Online Comment

Application H15-0955-25
Location Kirk Hill 355 Westhorpe Road Gosberton Westhorpe PE11 4ER
Proposal Extension to Existing Agricultural Building for Plant/Machinery, Storage & Workshop - Retrospective

Name Greg Watkinson
Address Conservation Officer

## Existing Floor Plan SCALE 1:100

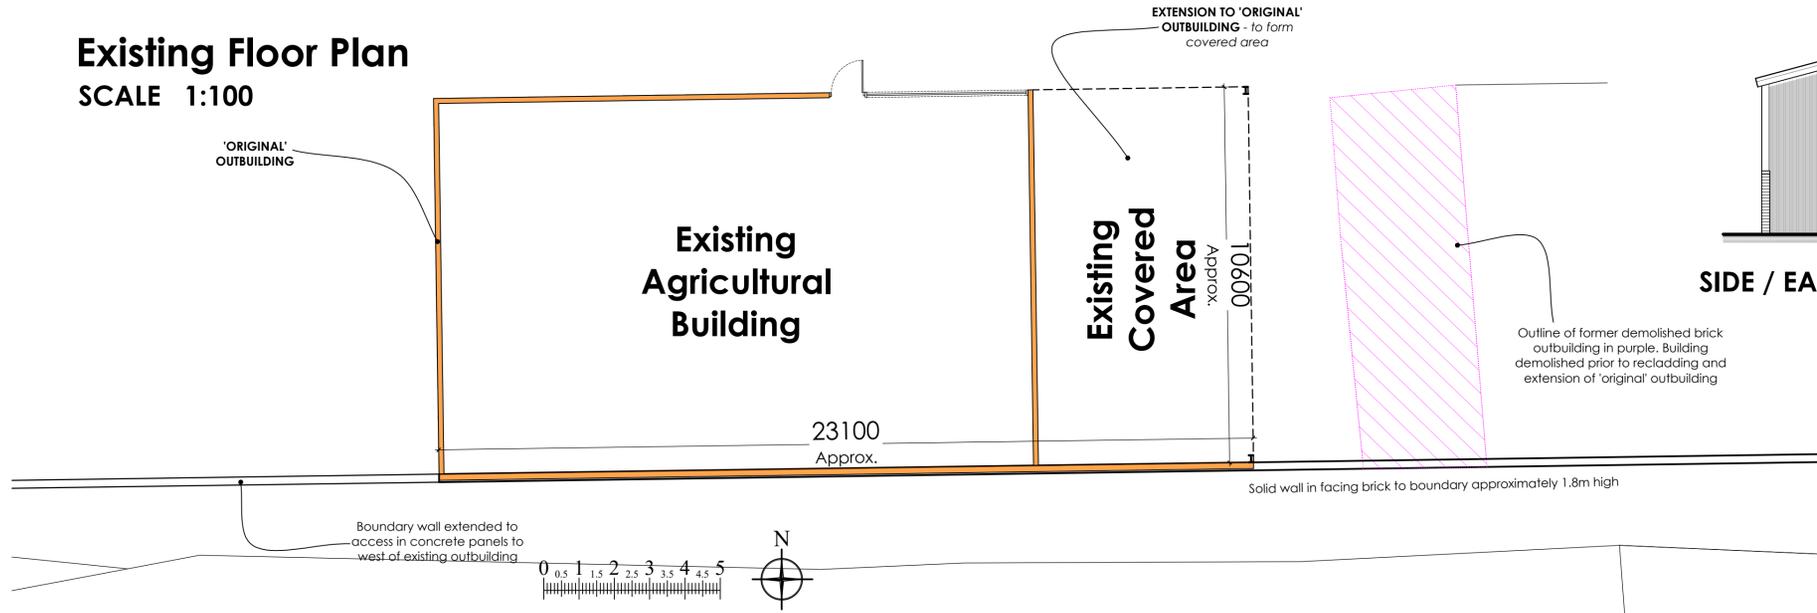
More information is required for an informed decision to take place on this application. The application includes a cursory mention of the fact that an original brick outbuilding has been demolished. Inspection of historic photography of the site shows that this brick outbuilding, whilst in poor condition and substantially altered with a corrugated roof, was an attractive historic agricultural range building forming an inherent part of Lincs HER entry Ref: MLI122465.

I would therefore suggest that a full Heritage Impact Assessment should be provided before this case may proceed further
